Ribble Valley Borough Council  
By email

**Your ref:** 3/2023/0263  
**Our ref:** DC/23/1339  
**Date:** 26-JUN-23

**Location: Eaves Hall Moor Lane West Bradford BB7 3JG**  
**Proposal: pursuant to variation of 14 (Drainage Scheme)**

Further to our review of the submitted documents SURFACE WATER DRAINAGE SCHEME and Drawing 10855-102, Rev P01 - Dated 06.09.21, United Utilities recommends that condition 14 is not discharged.

Title:
PROPOSED
DRAINAGE LAYOUT
SHEET 2 OF 2

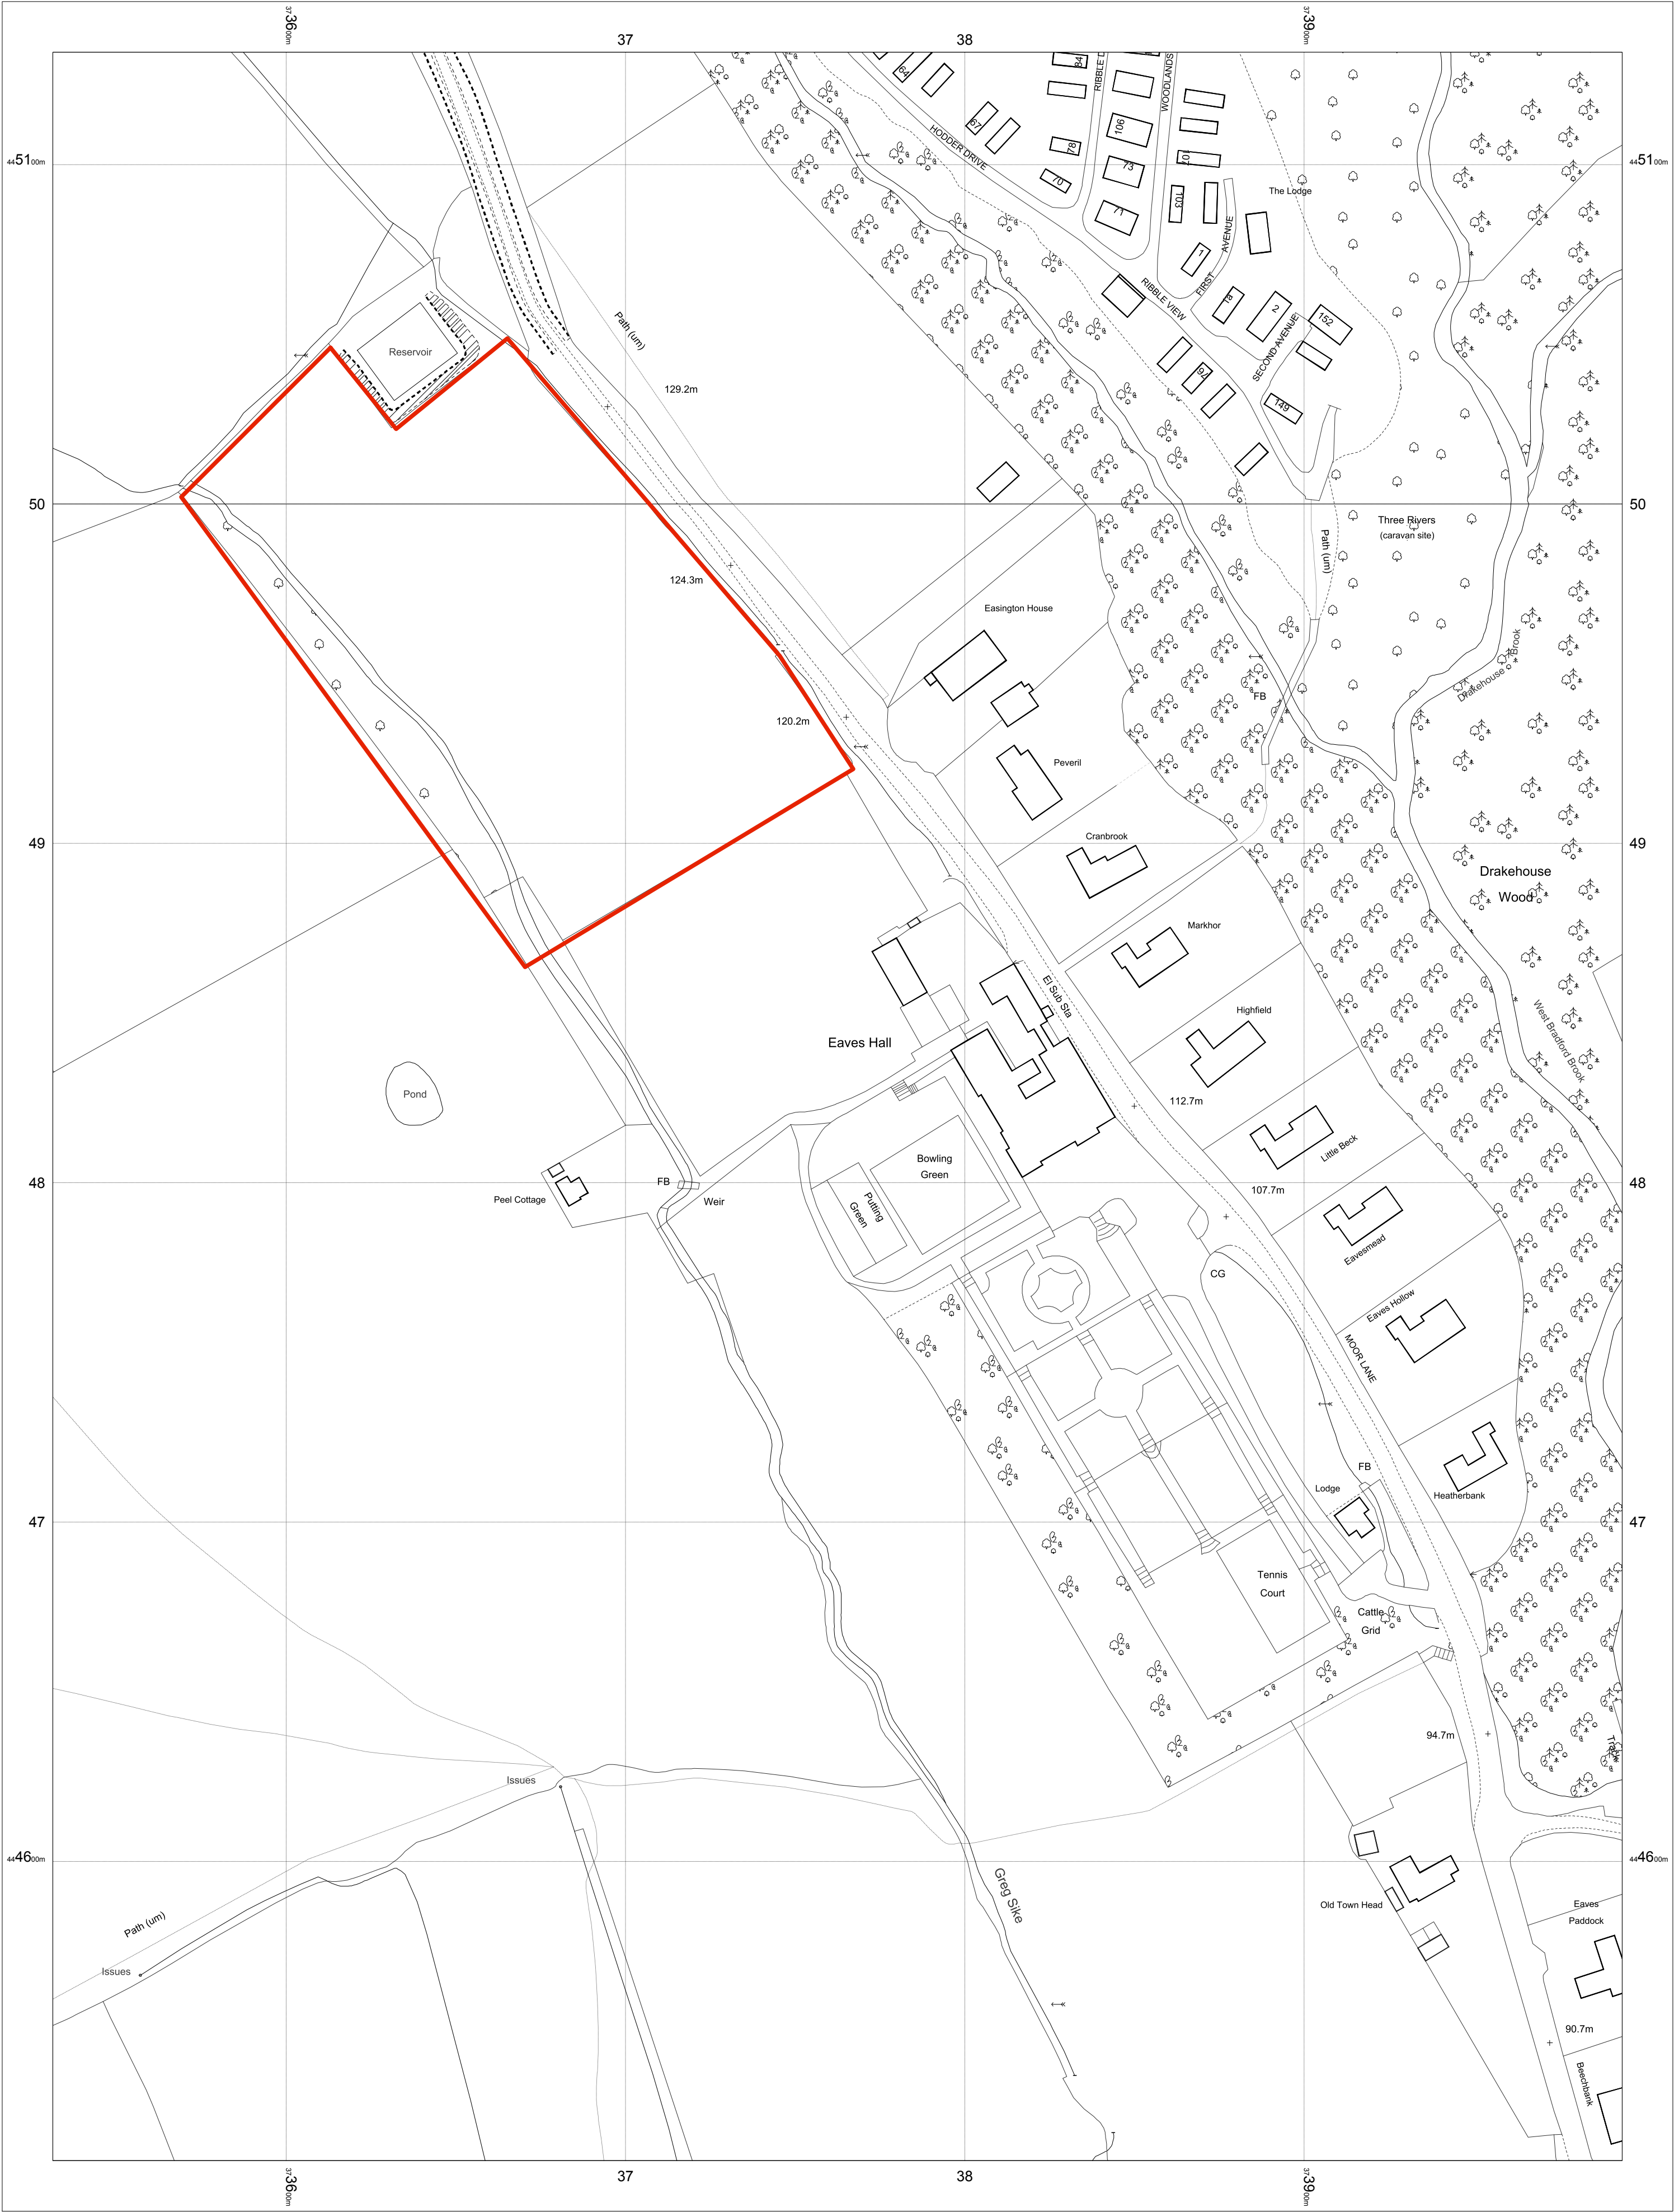
This is because drainage layout does not show how the surface water and the foul from the lodges will be dealt with.
